WEST SUSSEX COUNTY COUNCIL CONSULTATION

TO:	Arun District Council FAO: Anita Gardner
FROM:	WSCC Highway Authority - Matthew Bartle
DATE:	25 November 2019
LOCATION:	Pound Place Roundstone Lane Littlehampton BN16 4AL
SUBJECT:	A/161/19/DOC Approval of details reserved by condition imposed under ref A/9/19/PL relating to Condition Nos 3 - proposed surface water drainage and 16 - Construction & Environmental Management Plan.
RECOMMENDATION:	More Information (cond. 3)

Condition 3 - surface water drainage

DRAWING TITLE:
PROPOSED
DRAINAGE LAYOUT
SHEET 1 OF 3

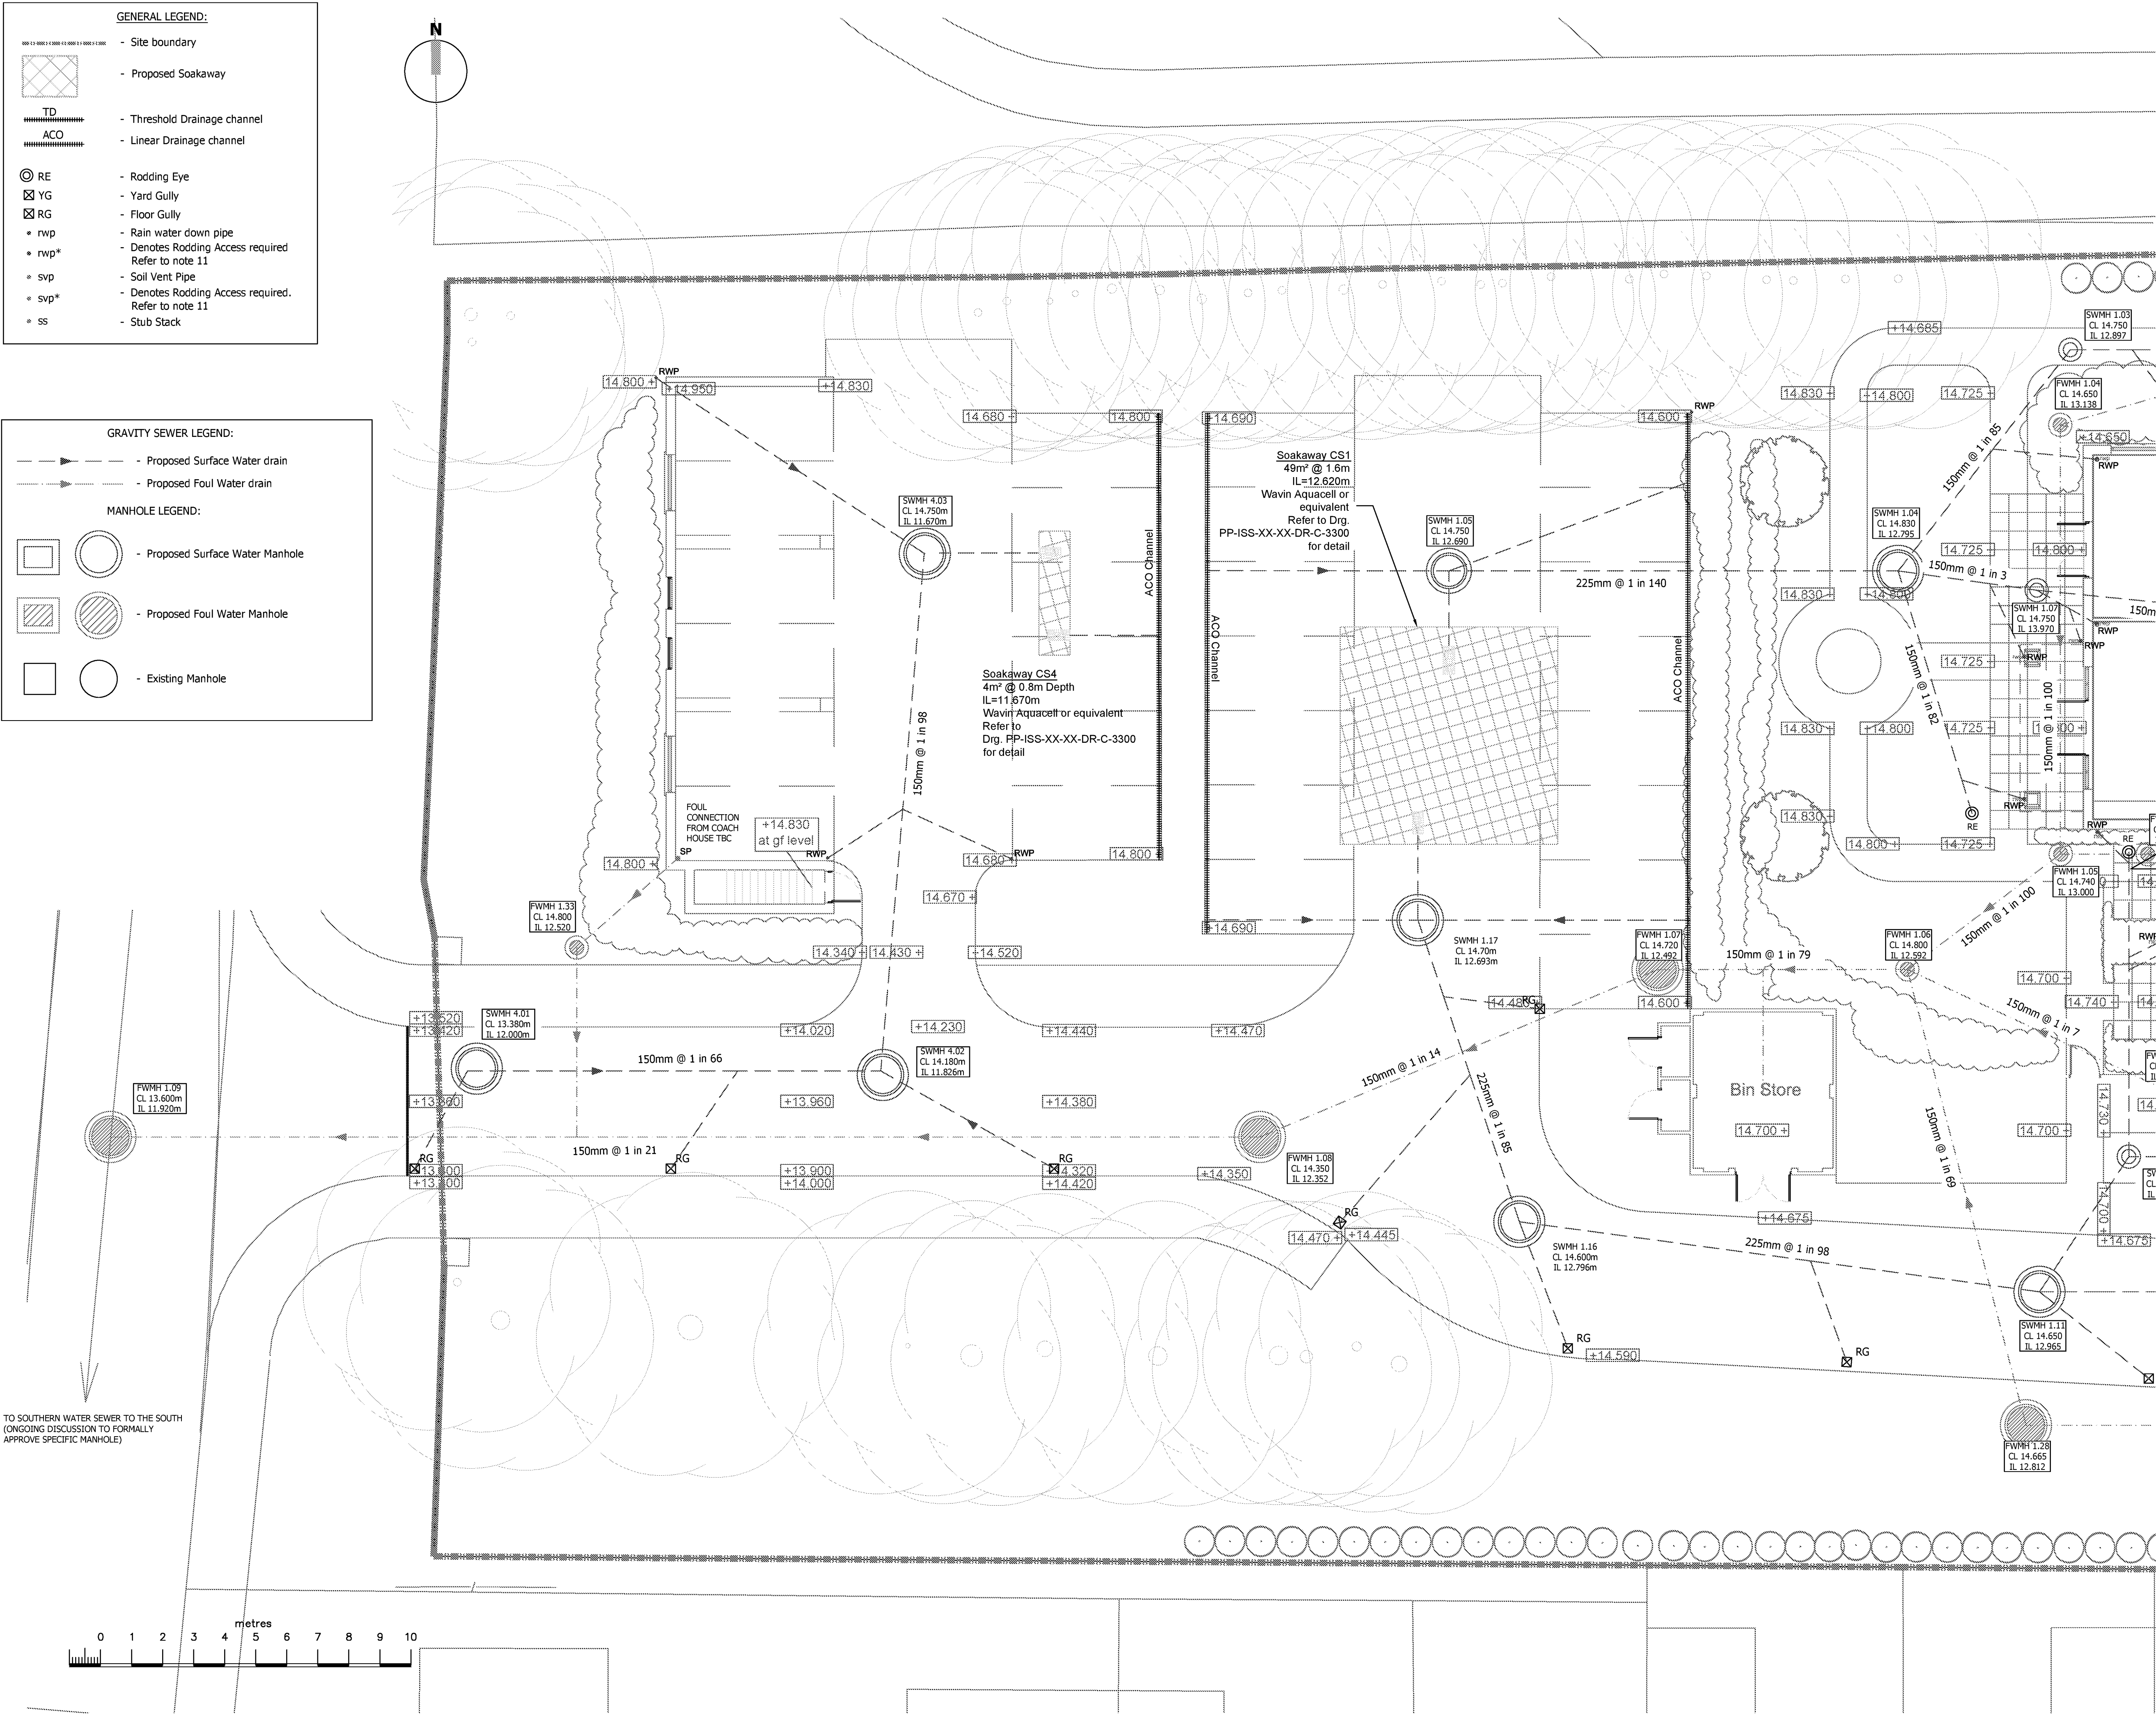
It is difficult to see from the supplied plans whether the drainage proposals are sufficient to prevent discharge of water onto Roundstone Lane. It would be helpful to the authority to have revised plans clearly indicating how water will be prevented from flowing onto the public road. Alternatively, an explanation might be provided of how the current proposals will meet this requirement.
